From: Alexandra Munday <[REDACTED]>
Sent: 03 April 2014 15:08
To: Daun Johnson
Subject: RE: Unit 4 Oldlands Way, Bognor Regis (BE/32/14/PL)
Attachments: Block plan Rev A.pdf

From: Alexandra Munday <[REDACTED]>
Sent: 02 April 2014 11:41
To: Planning
Subject: Unit 4 Oldlands Way, Bognor Regis (BE/32/14/PL)

UNIT 4 , OLDLANDS WAY , BOGNOR REGIS

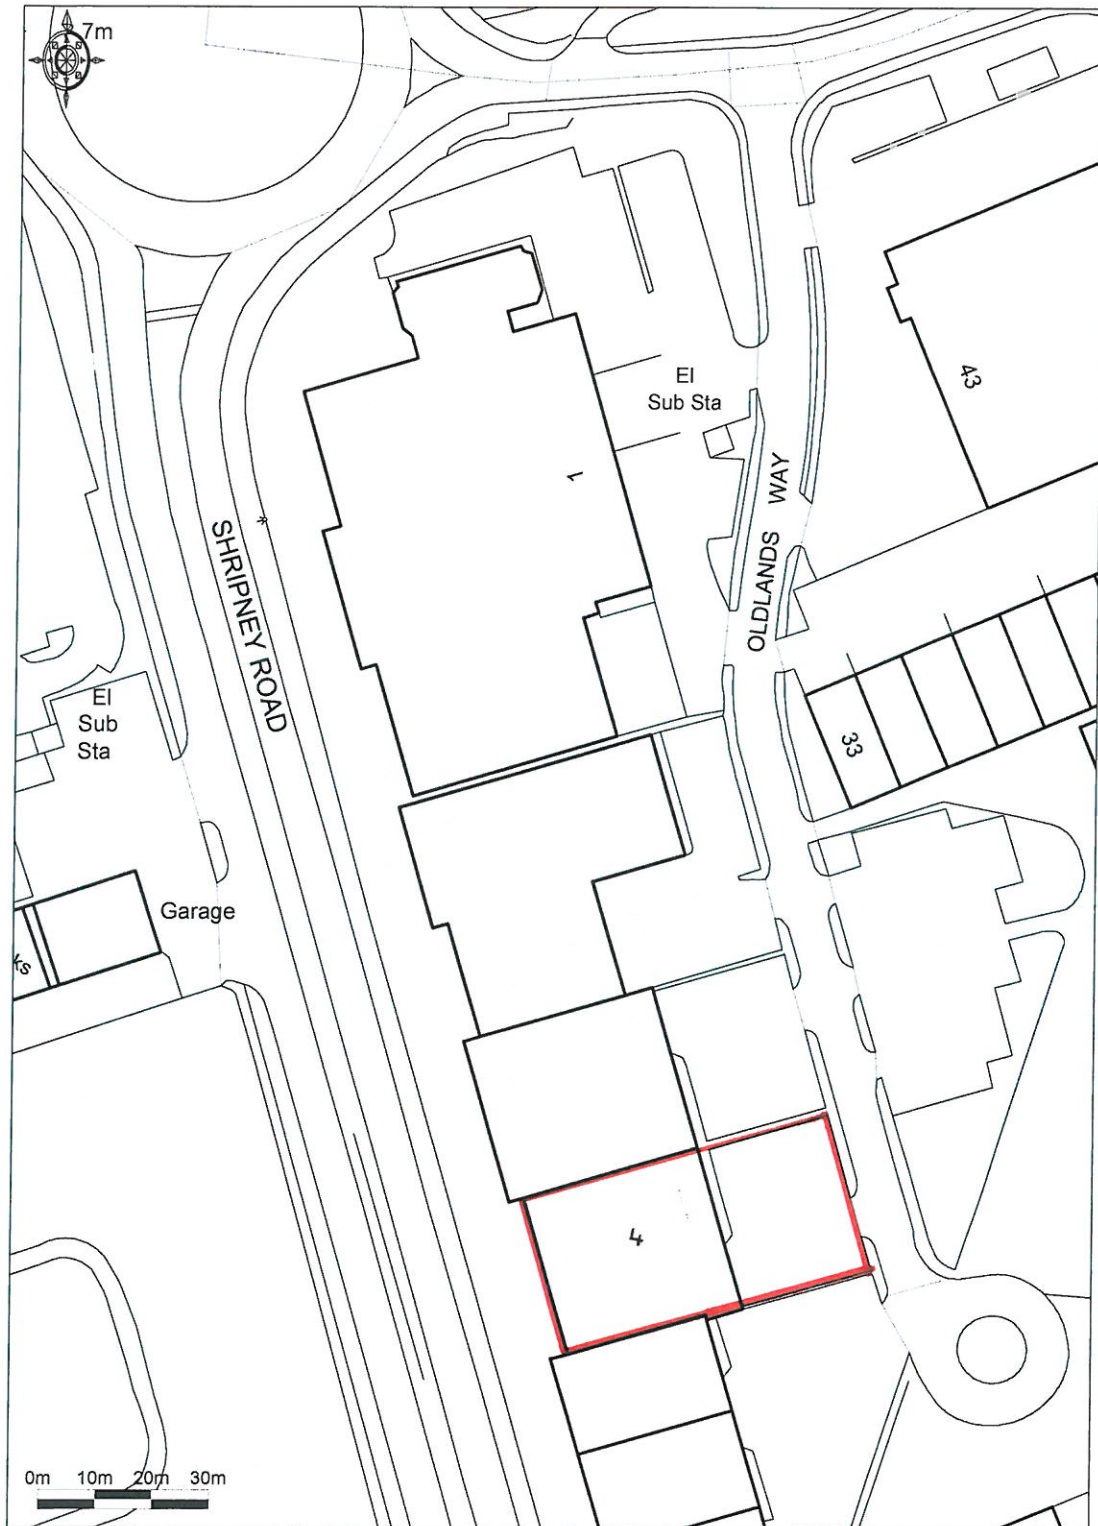
The block plan needs one named road. I can see 'ol' on the plan as a named road, but it is not complete. Please put a complete named road on the block plan.

Please see attached. I trust this now meets your requirements.
